The Sizewell C Project

3.1 Second Draft Development Consent Order Addendum: Proposed Work No.s Changes

January 2021

SIZEWELL C (NUCLEAR GENERATING STATION) ORDER
SECOND DRAFT DEVELOPMENT CONSENT ORDER ADDENDUM: PROPOSED WORK NO.S CHANGES ¹

DRAWING TITLE:
NORTHERN PARK AND RIDE
PROPOSED PARAMETER PLAN

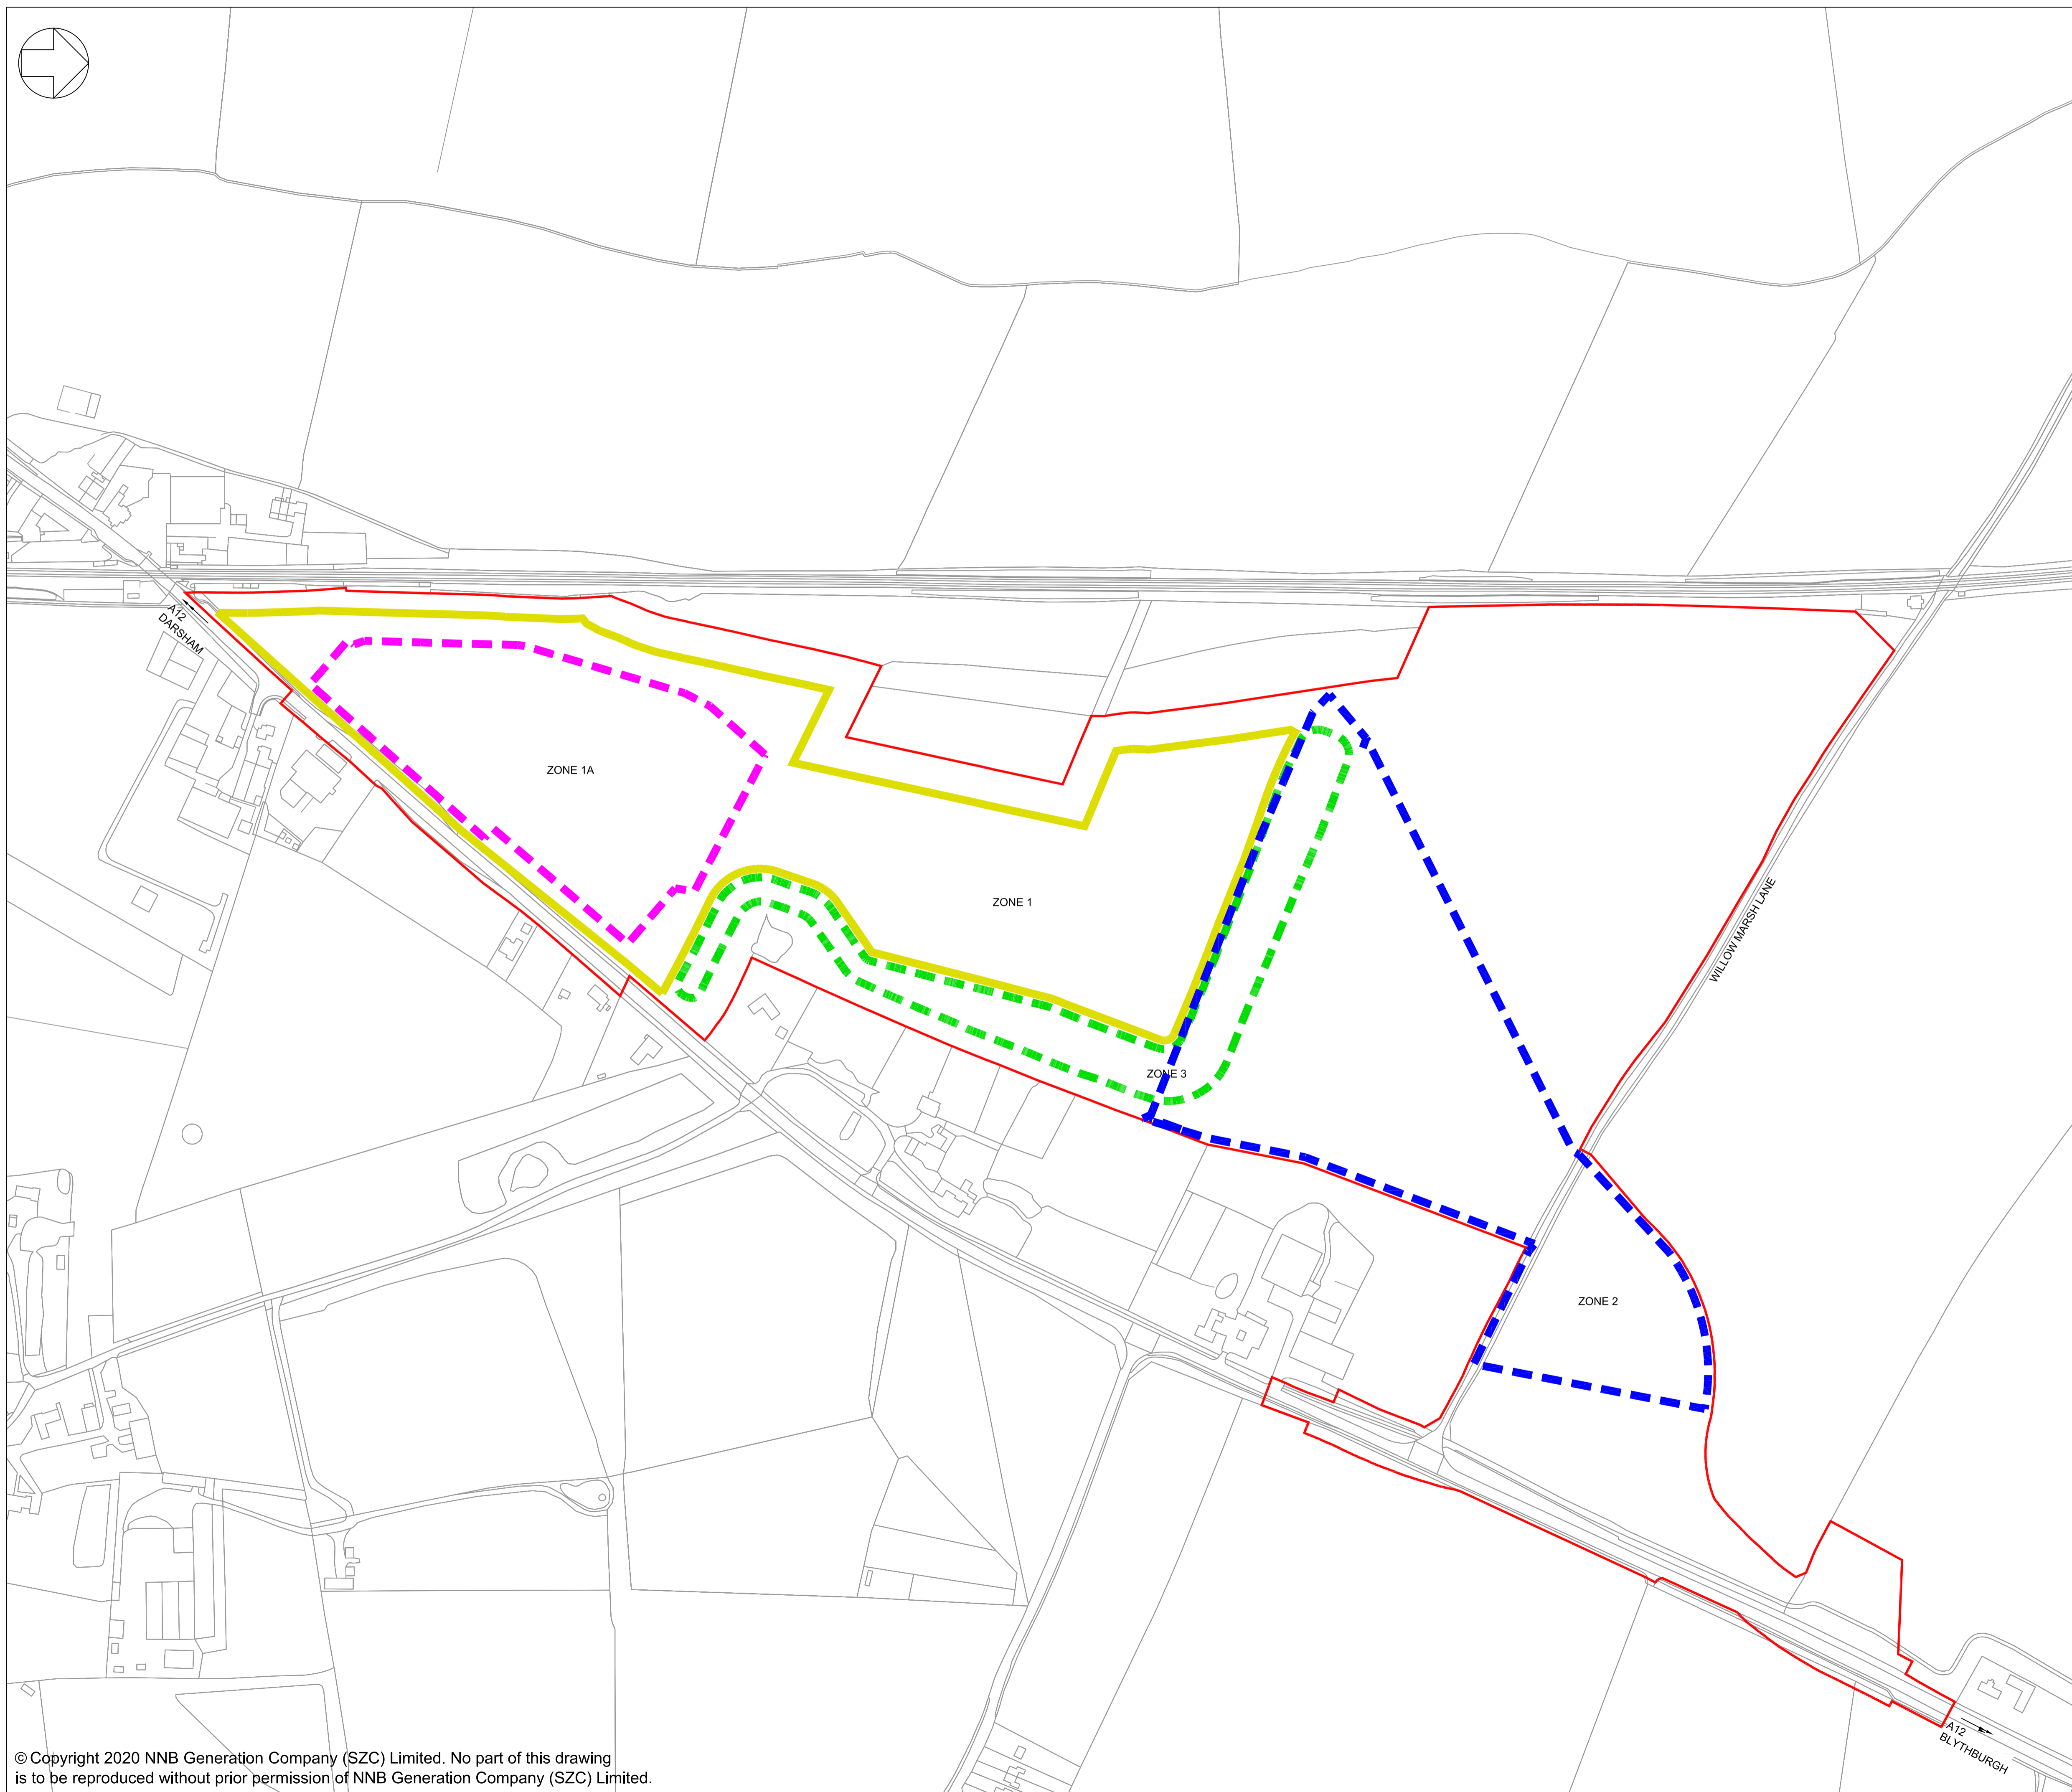
DCO Ref (Art/Sched)	ExA Procedural Decision reference	Change made	DCO Revision No.
		Park to include up to 15 additional parking spaces."	
Schedule 1, Part 1, Work No 1D	23 October, Annex A, numbers 17, 19 and 21	<p>Updates to Work No 1D to clarify the split between operational and outage car parking and to more closely align the works description to the description of development in the Environmental Statement. The amendments comprise:</p> <ul style="list-style-type: none"> • Work No 1D(gg) – "688" has been removed and replaced with "112"; • Work No 1D(hh) – "up to 576" has been inserted before "outage car parking" and "spaces" has been inserted after "outage car parking"; • Work No 1D(jj) – "to include workshops, civils store and general store" has been inserted after "administrative buildings"; and • Work No 1D(hh) – "accommodation" has been inserted after "office". 	2
Schedule 1, Part 1, Work No 5	22 December, Annex A, Part G, Q3	<p>Updates to Work No 5 (sports facilities) to more closely align the works description to the description of development in the Environmental Statement. The amendments comprise:</p> <ul style="list-style-type: none"> • After "including" the words "one 3G pitch and two multi-use games 	2

DCO Ref (Art/Sched)	ExA Procedural Decision reference	Change made	DCO Revision No.
		<p>area courts, with” have been inserted;</p> <ul style="list-style-type: none"> • Removal of “open space, sports facilities and”; and • After “associated” the removal of “structures” and “plant” and the insertion of “fencing” and “floodlighting”. 	
Schedule 1, Part 1, Work No 9	23 October, Annex A, Part B	<p>Updates to Work No 9 (northern park and ride) to more closely align the works description to the description of development in the Environmental Statement.</p> <p>After “(a) A temporary park and ride facility” the words “with up to 1, 250 car parking spaces (excluding pick-up spaces, minibuses/van/bus spaces, motorcycle spaces and bicycle spaces)” have been inserted.</p>	2
Schedule 1, Part 1, Work No 10	23 October, Annex A, Part C	<p>Updates to Work No 10 (southern park and ride) to more closely align the works description to the description of development in the Environmental Statement.</p> <p>After “(a) A temporary park and ride facility” the words “with up to 1, 250 car parking spaces (excluding pick-up spaces, minibuses/van/bus spaces, motorcycle spaces and bicycle spaces)” have been inserted, and “traffic incident management area” has been inserted as</p>	2
